From: Amanda Scholes on behalf of Planning.Responses
Sent: 06 July 2018 08:51
To: Planning Scanning
Subject: FW: FAO Michael Eastham: Highways England response - A/40/18/OUT - Land North of Water Lane Angmering
Attachments: ITB9105-025A HE TA Clarifications.pdf; ITB9105-GA-024B.PDF; 20180521 - HEPR - A_40_18_OUT - Land North of Water Lane Angmering.pdf

Site: Land North of Water Lane, Angmering

Planning Application No: A/40/18/OUT

Highways England reference: HAMIS 81058

TITLE: PROPOSED IMPROVEMENT SCHEME TO A280 / A27 / TITNORE LANE ROUNDABOUT			
PROJECT: LAND SOUTH OF WATER LANE, ANGMERING		CLIENT: RYDON HOMES, GLEESON DEVELOPMENTS LTD

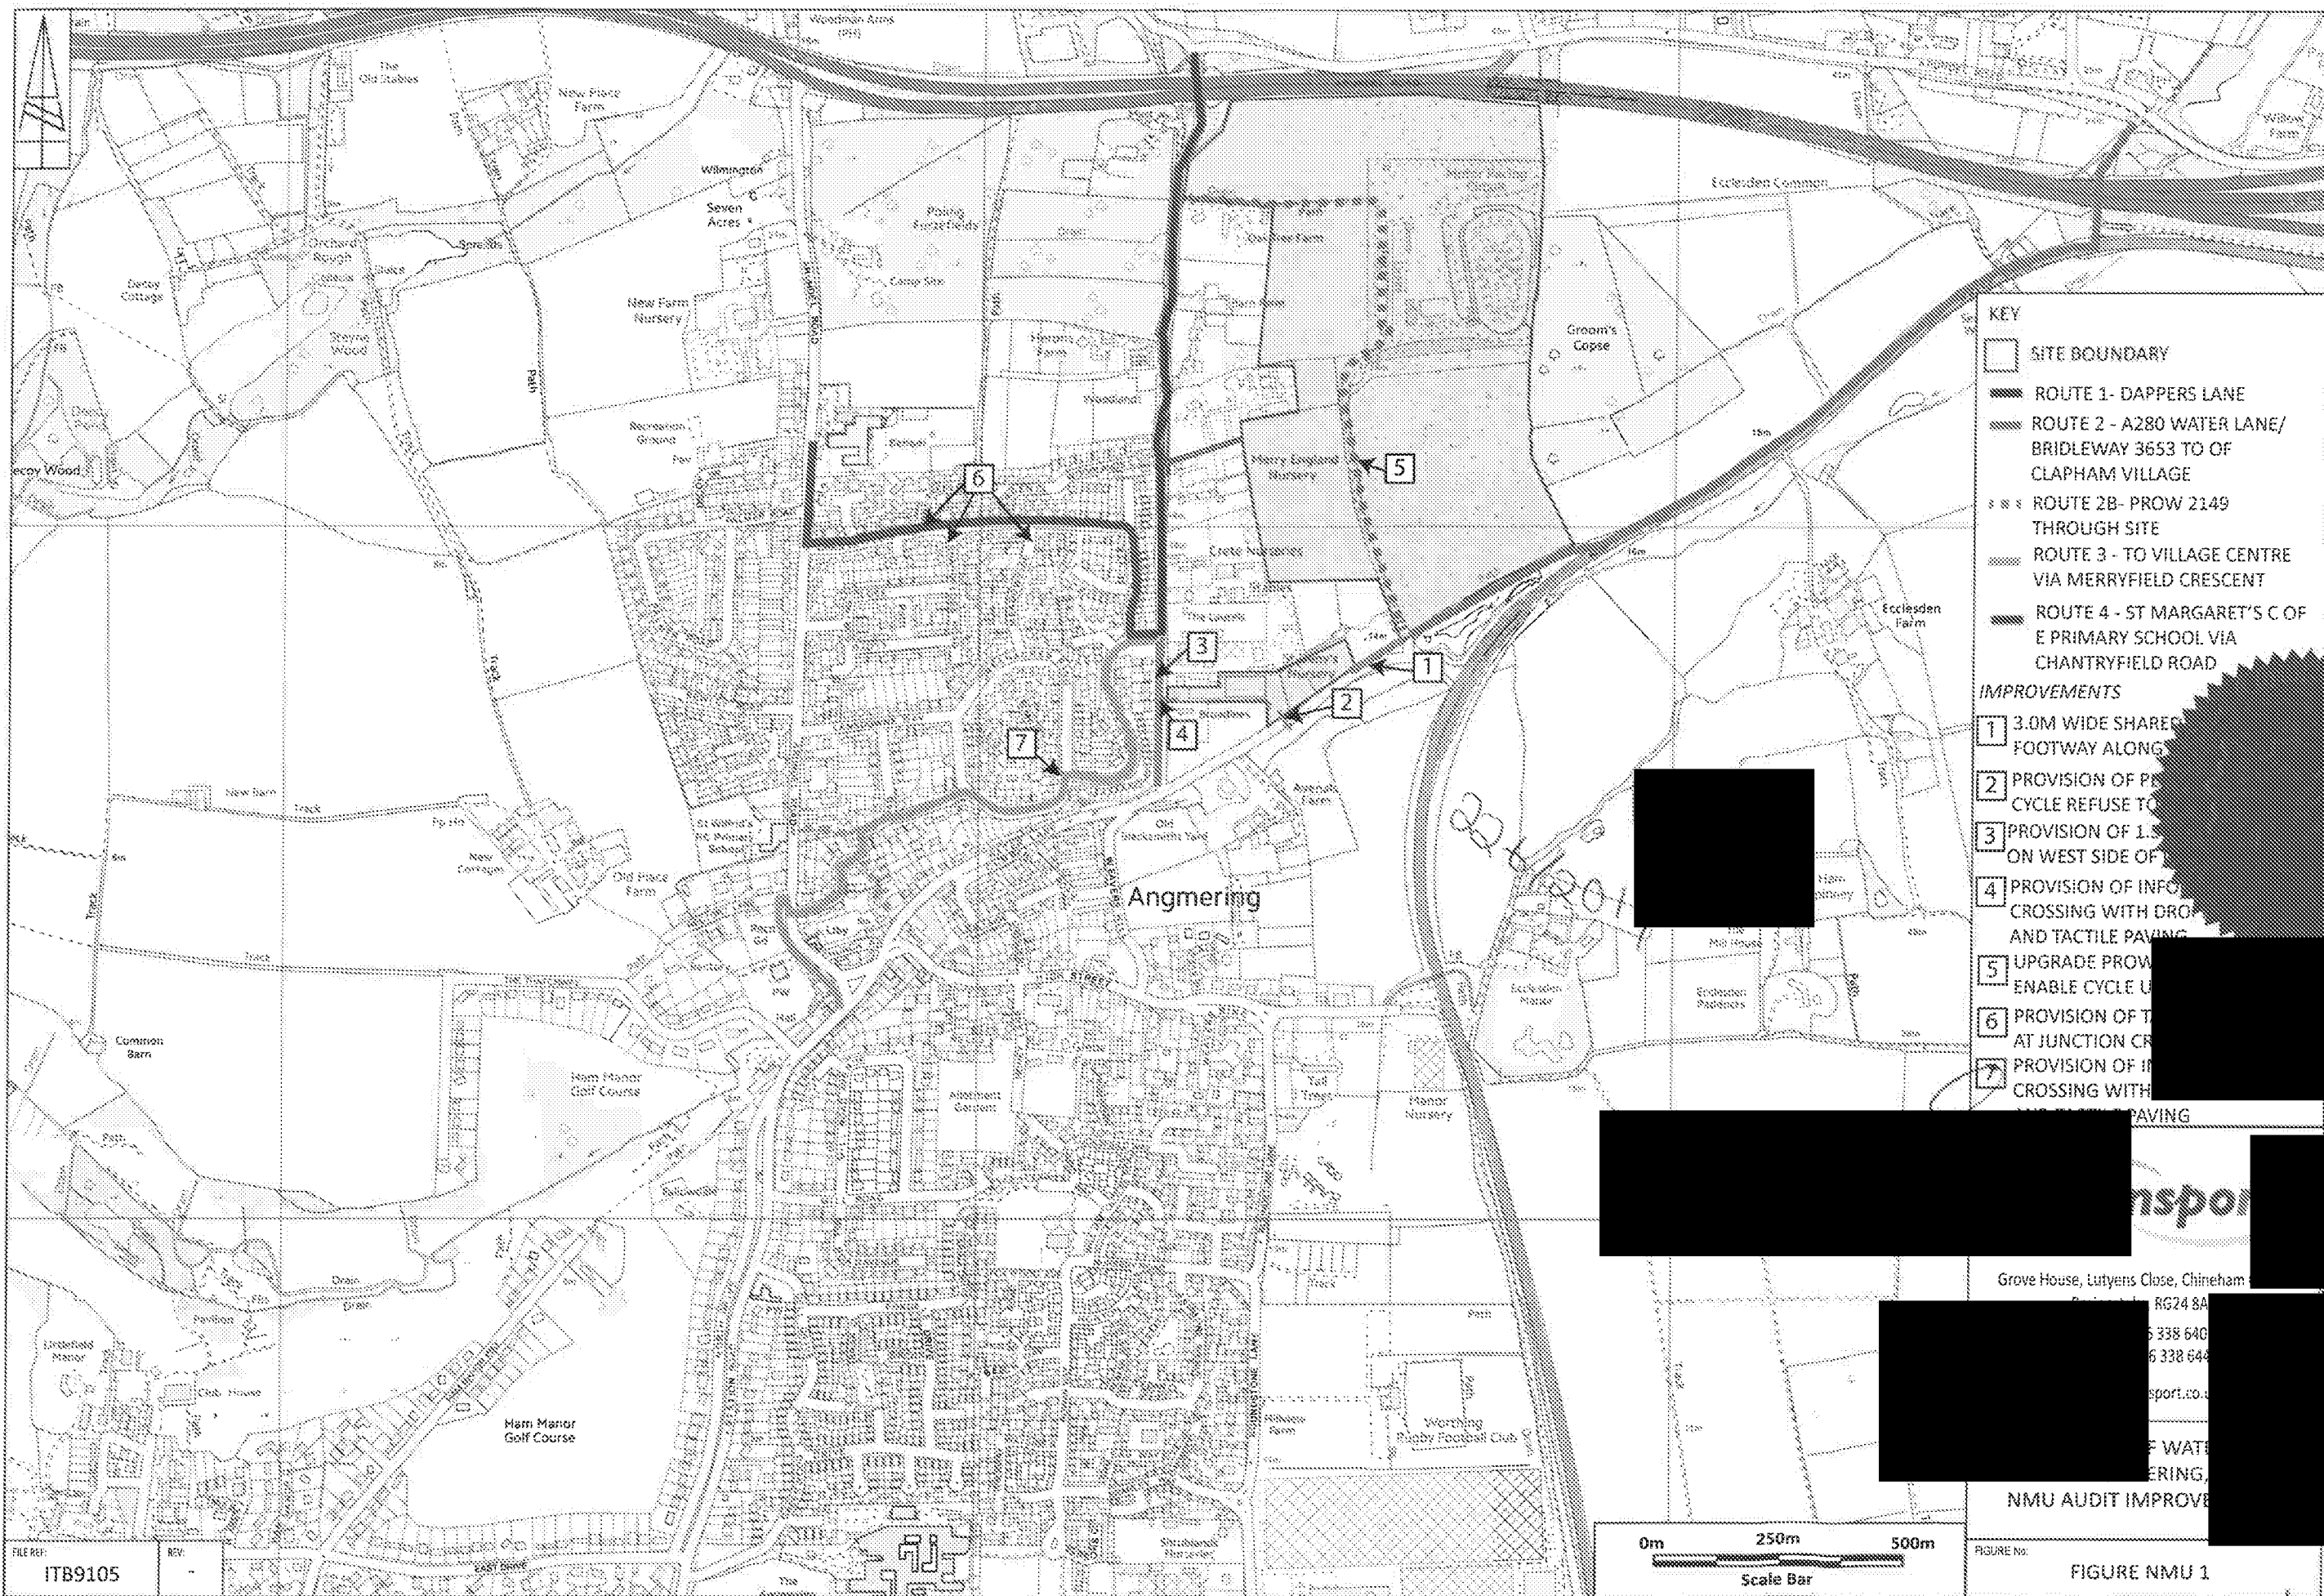
"Prior to the occupation of 250 dwellings within the permitted development, the improvement works at the A280/A27/Titnore Lane Roundabout junction shall be completed and open to the travelling public as shown on i-Transport's drawing number ITB9105-GA-024 "Proposed Improvement Scheme to A280/A27/Titnore Lane Roundabout" (or such other scheme of works substantially to the same effect, as may be approved in writing by the local planning authority (who shall consult with Highways England)), including any necessary transfer of lands to enable the construction and maintenance of the scheme."

Reason: *The modifications have been proposed to provide sufficient capacity at the A280 / A27 / Titnore Lane Junction. This is to ensure that the A27 Trunk Road continues to be an effective part of the national system of routes for through traffic in accordance with section 10 of the Highways Act 1980 and to satisfy the reasonable requirements of road safety.*
